Our Case Number: ABP-319306-24

Re: Proposed development of Cavan Town Sports Campus
in the townlands of Kilnavara, Lurganboy (Loughtee Upper By), Creighan and Rosscolgan in Cavan
Town.

Your Ref: ABP-319306-24
Our Ref: 177AE Cavan Sports Campus
(Please quote in all related correspondence)

177AE: Proposed development of Cavan Town Sports Campus: in the townlands of Kilnavara, Lurganboy (Loughtee Upper By), Creighan and Rosscolgan in Cavan Town.

Proposed Bridge Plan
Scale: 1:100

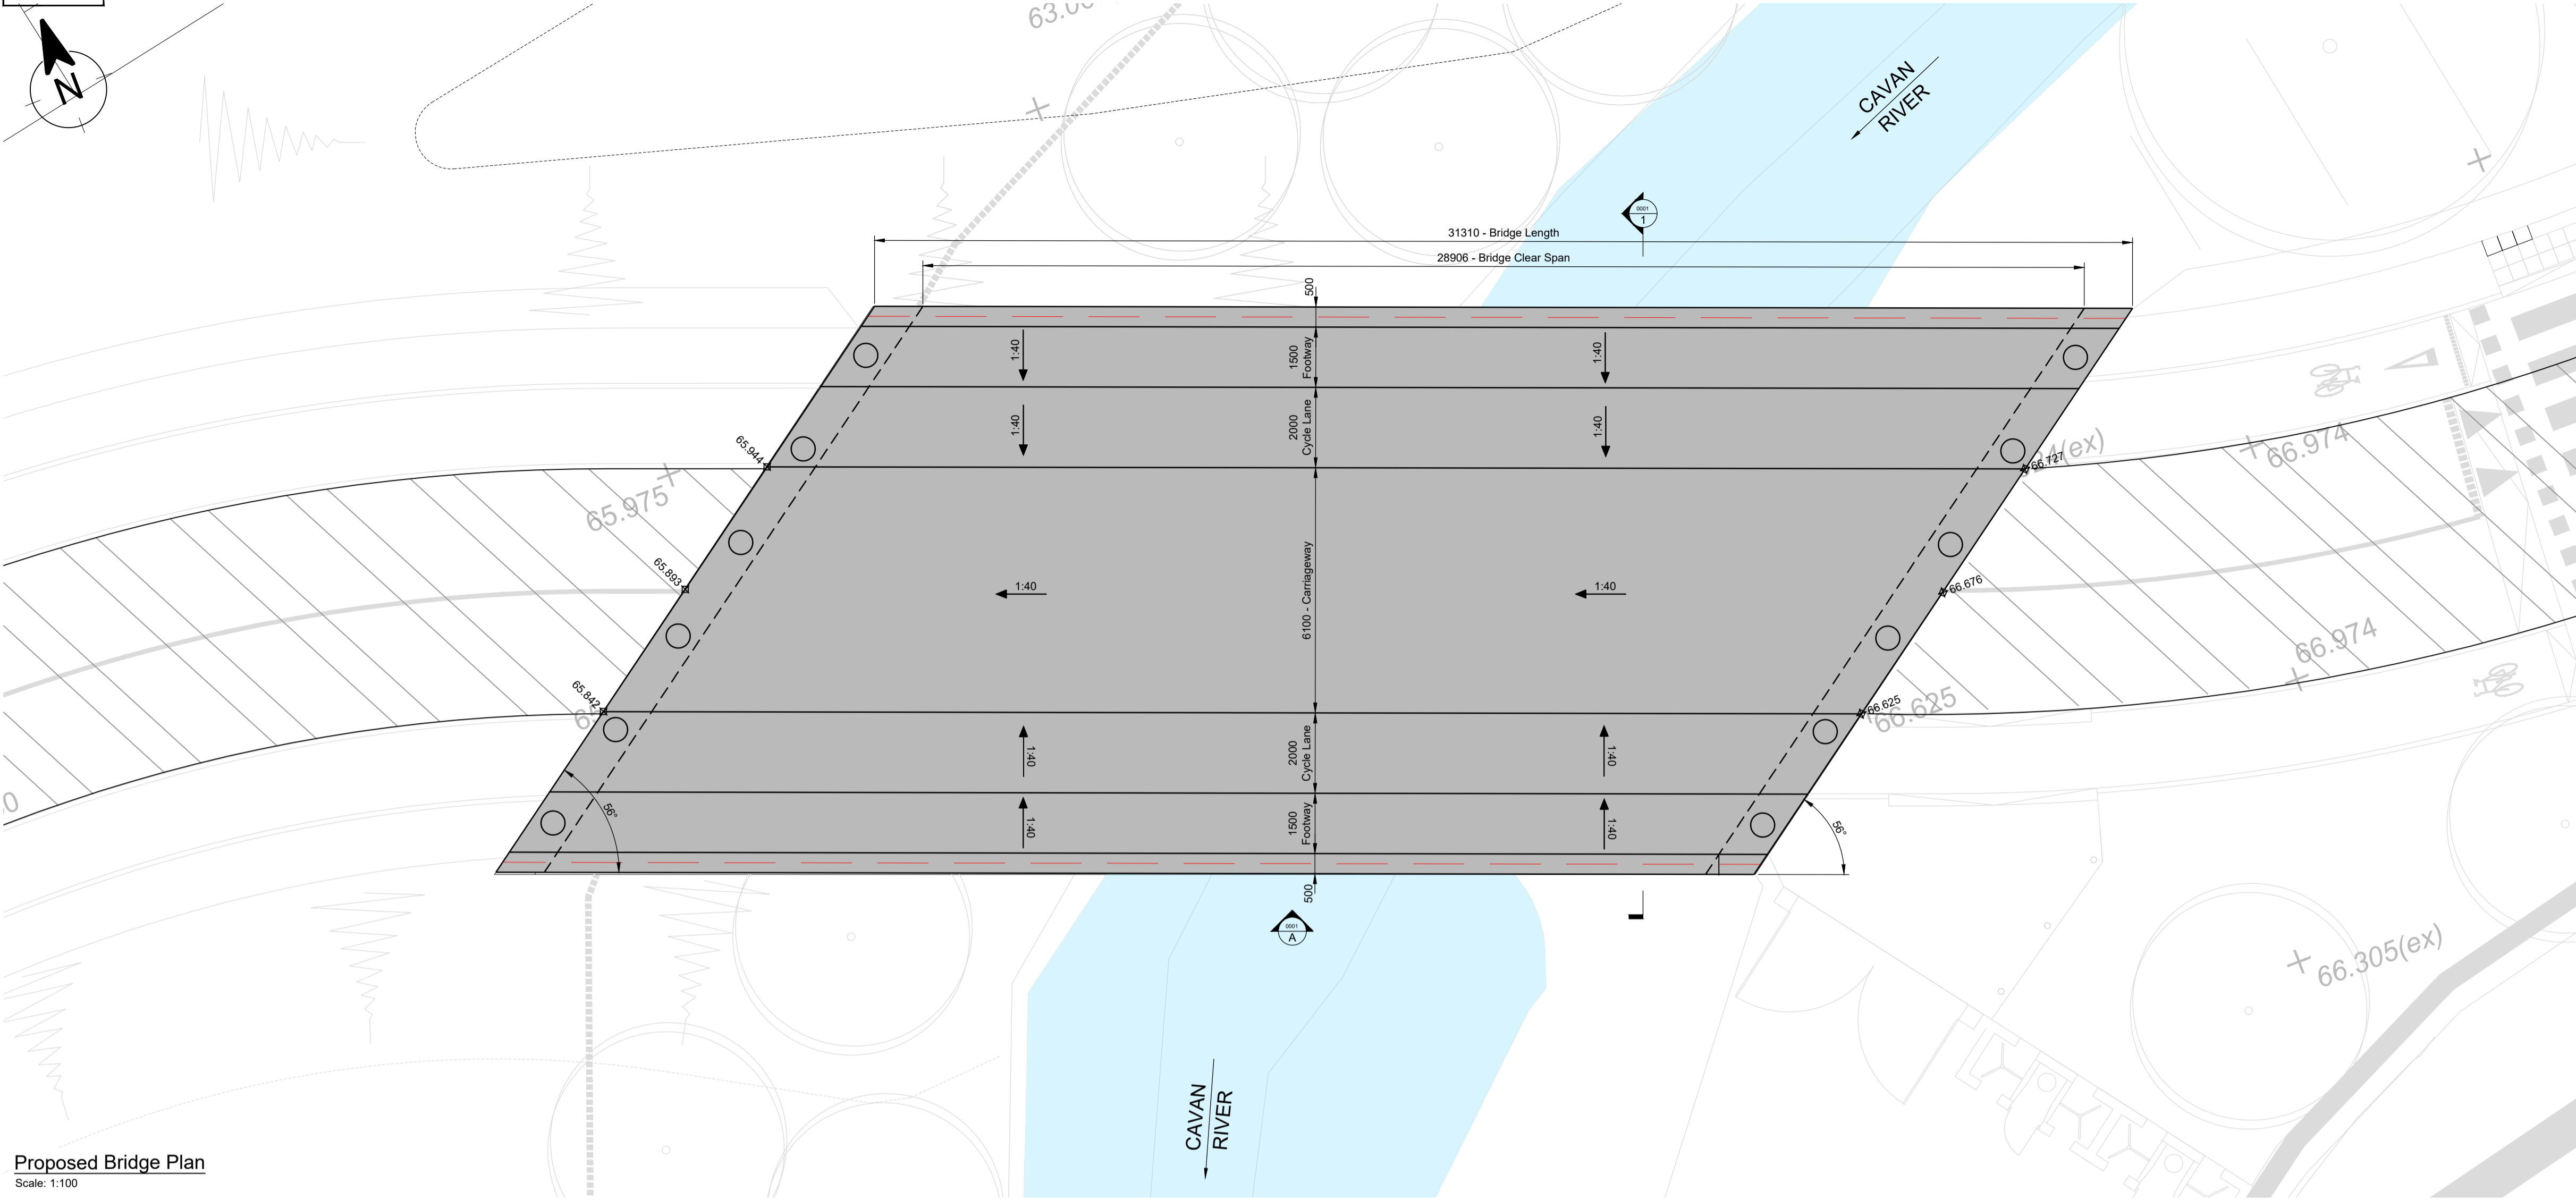
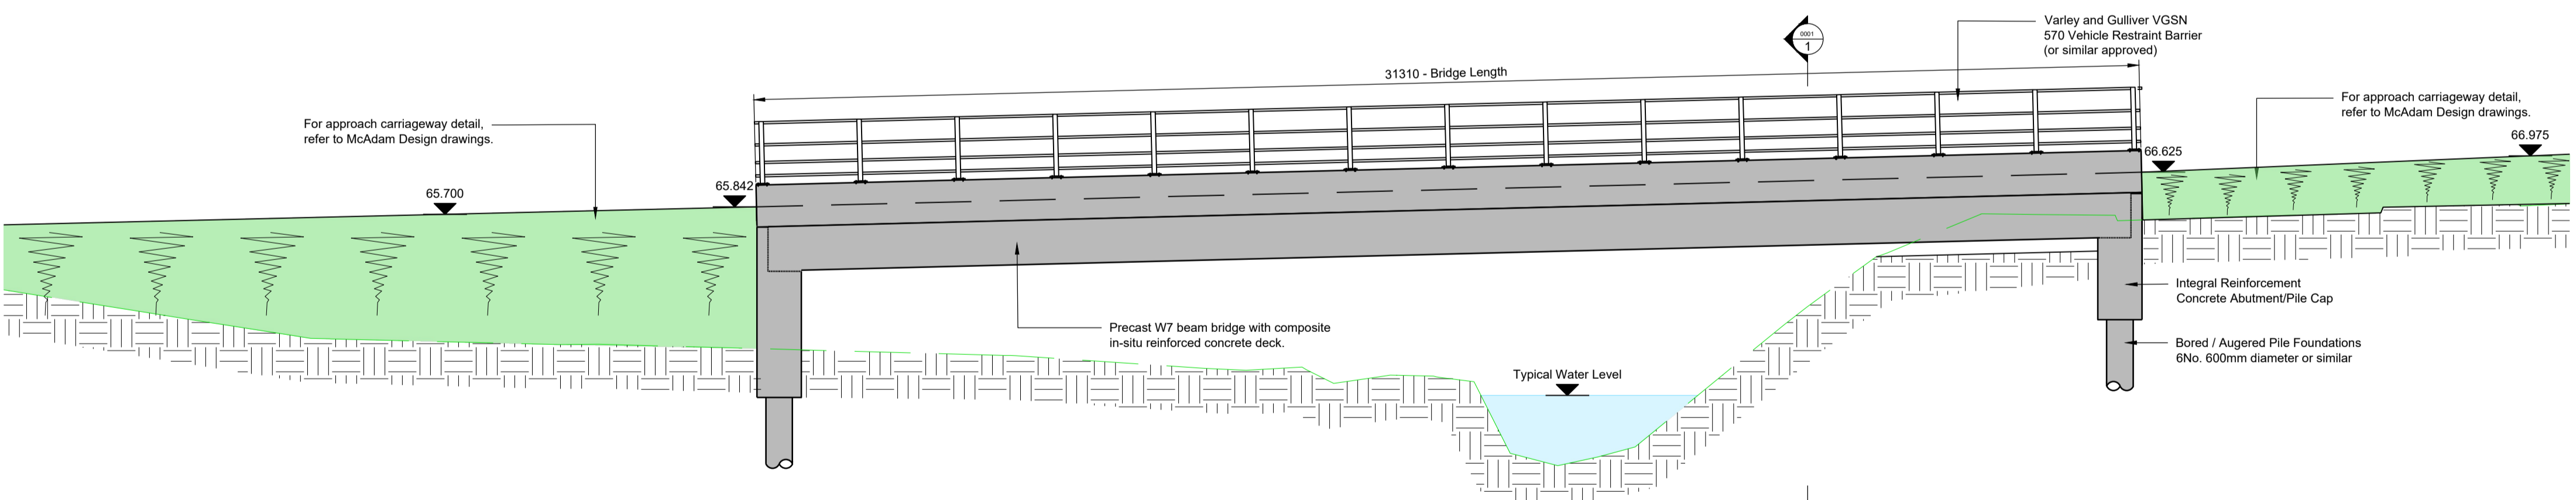
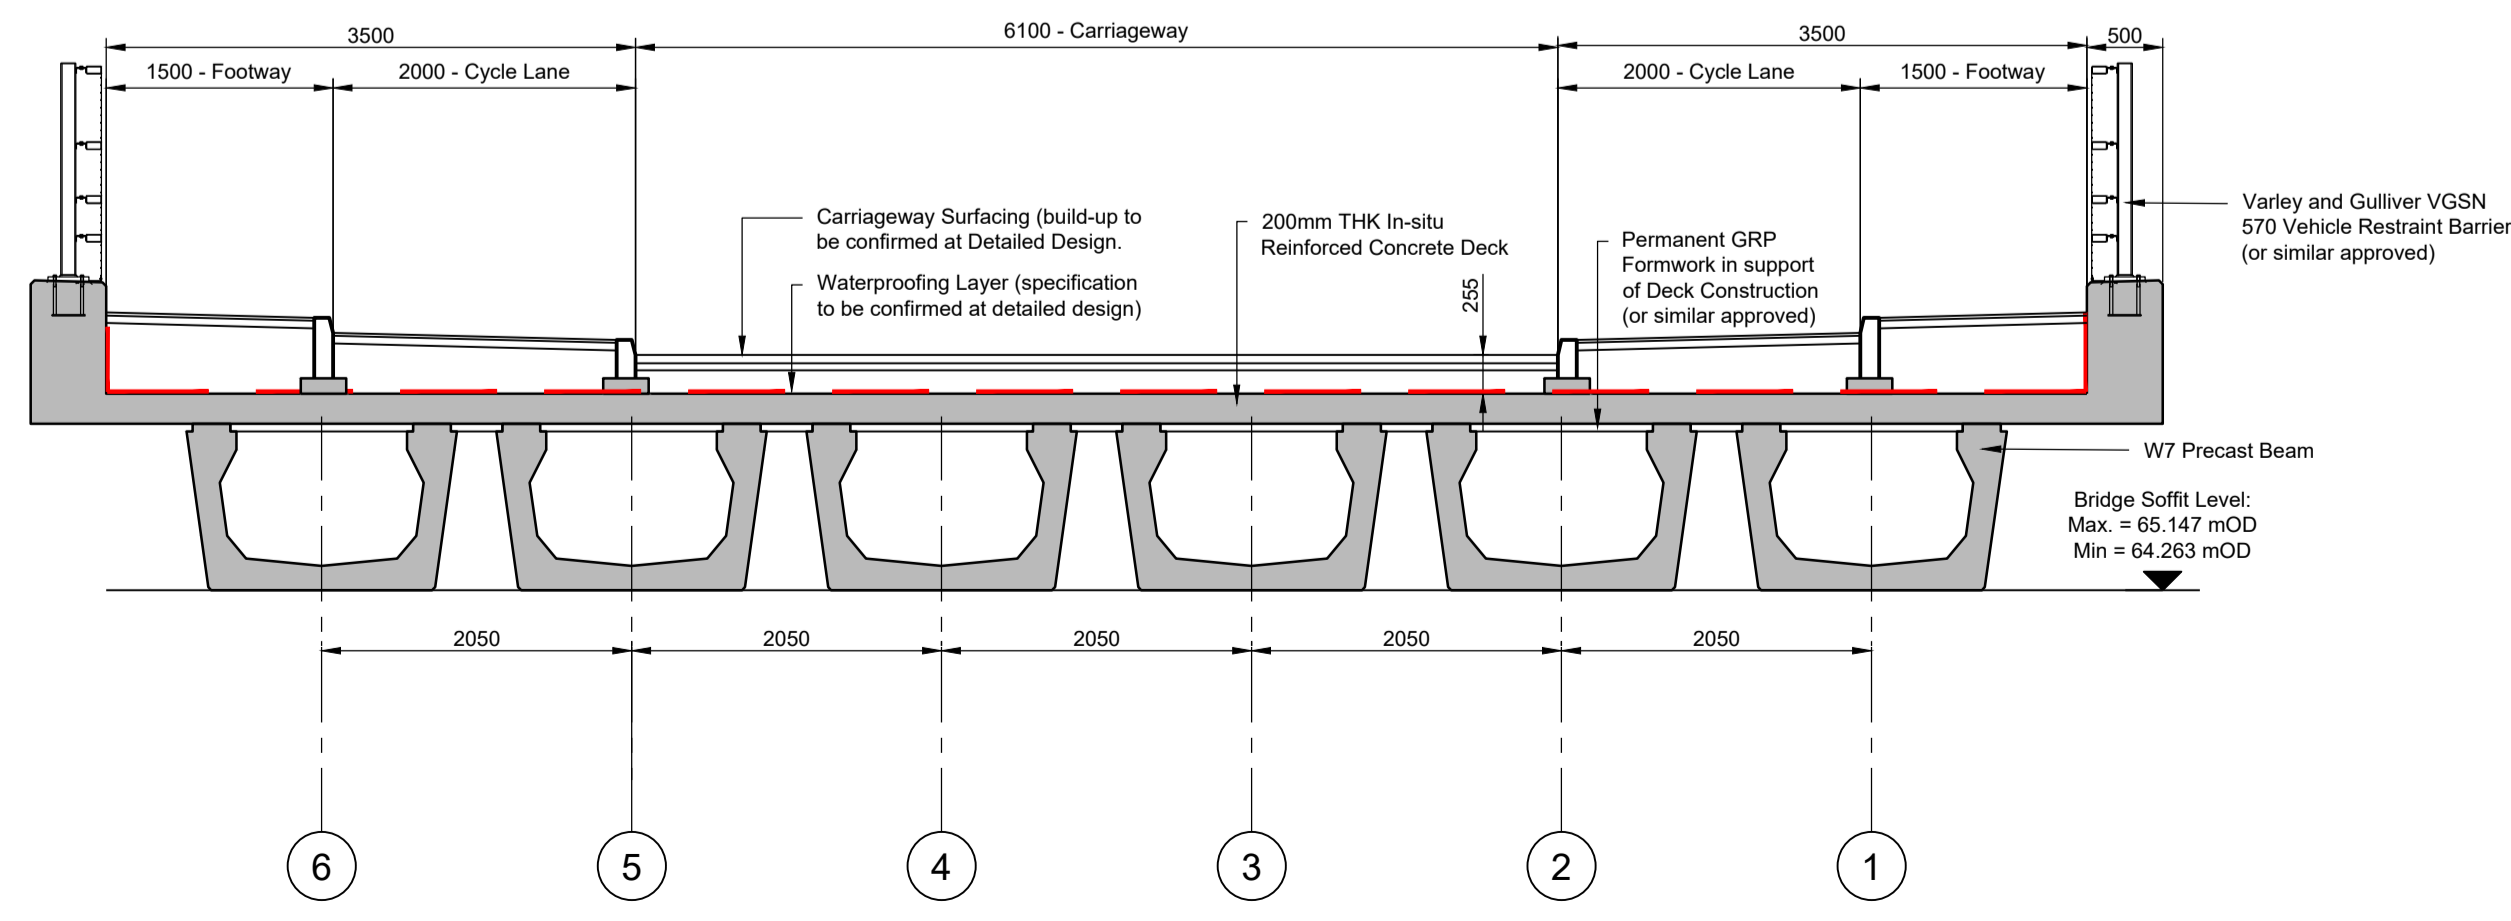
There is very little objective information regarding the works required to construct the proposed new outfalls, the bridge proposed across river and the culverting of the minor watercourse. It is recommended that further information is requested including description of these works, the potential impacts on habitats and species during both construction and operation and how these will be mitigated.
